OXFORDSHIRE COUNTY COUNCIL'S RESPONSE TO CONSULTATION ON THE FOLLOWING DEVELOPMENT PROPOSAL

Application no: 22/02866/OUT

Proposal: OUTLINE planning application for up to 120 dwellings, vehicular and pedestrian access off Ploughley Road, new pedestrian access to West Hawthorn Road, surface water drainage, foul water drainage, landscaping, public open space, biodiversity and associated infrastructure. Access off Ploughley Road is not reserved for future consideration

Location: Land East Of, Ploughley Road, Ambrosden

PROPOSED CYCLE ACCESS  
SCALE 1:100

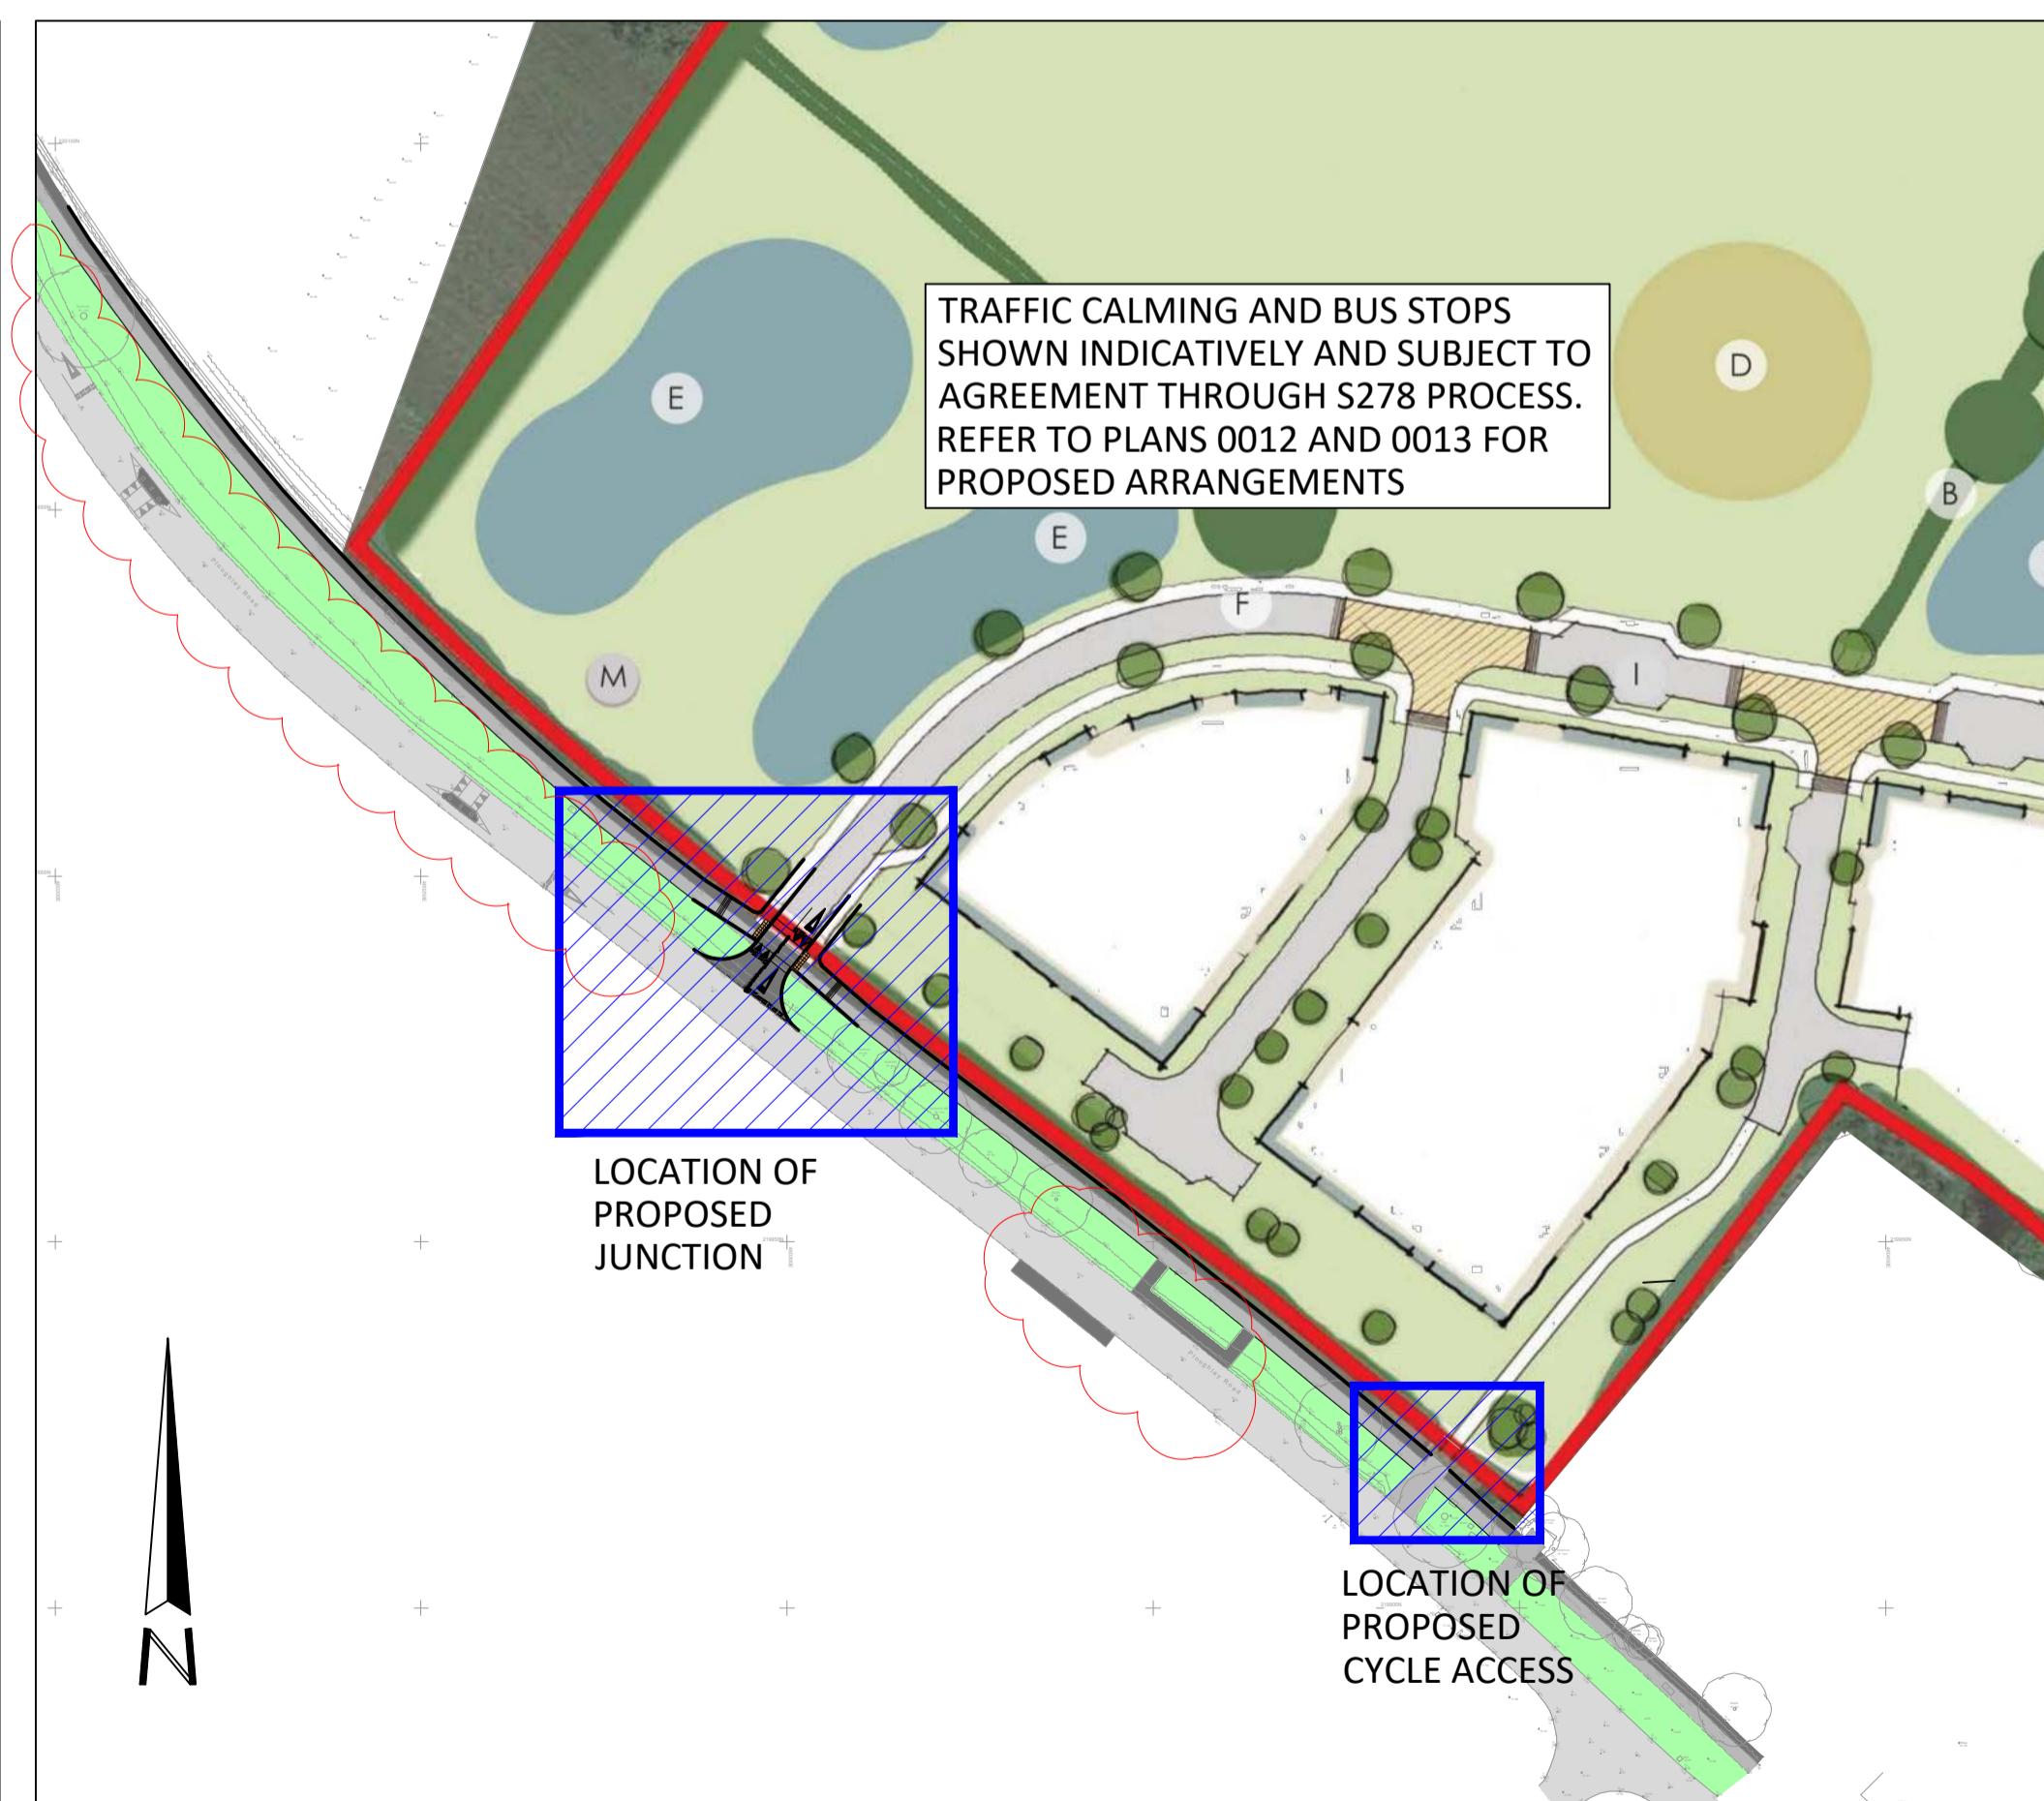
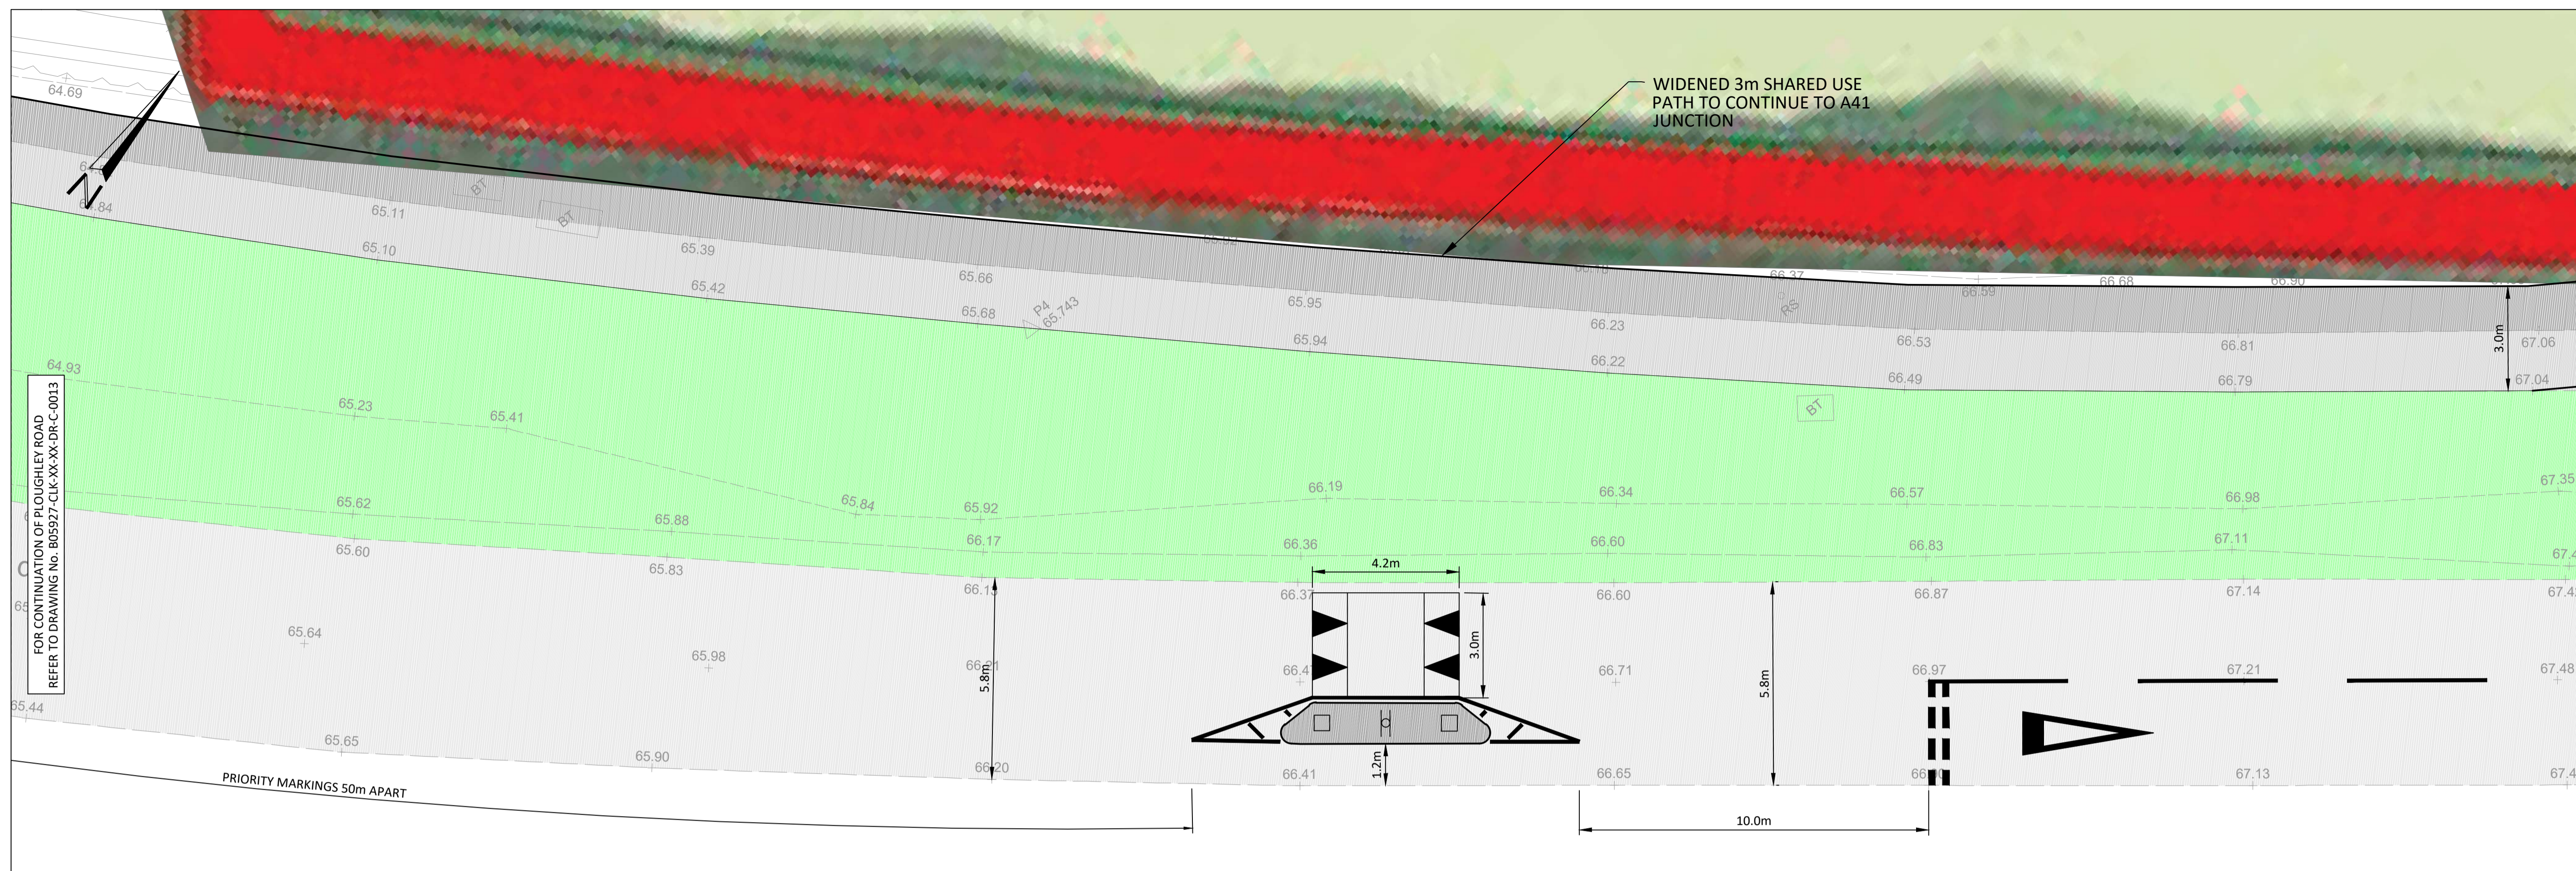
- A new site access bellmouth junction on Ploughley Road (as shown indicatively on Clarkebond drawing B05927-CLK-XX-XX-DR-C-0007 Rev. P06).
- Relocation of the speed limit signs, village gateway and “dragon’s teeth” road markings, including public consultation and TRO (as shown indicatively on Clarkebond drawing B05927-CLK-XX-XX-DR-C-0012 Rev. P02).

- Widening of the cycletrack beside Ploughley Road to 3.0m (where practical to do so) between the A41 and Briar Furlong (as shown indicatively on Clarkebond drawing B05927-CLK-XX-XX-DR-C-0007 Rev. P06).
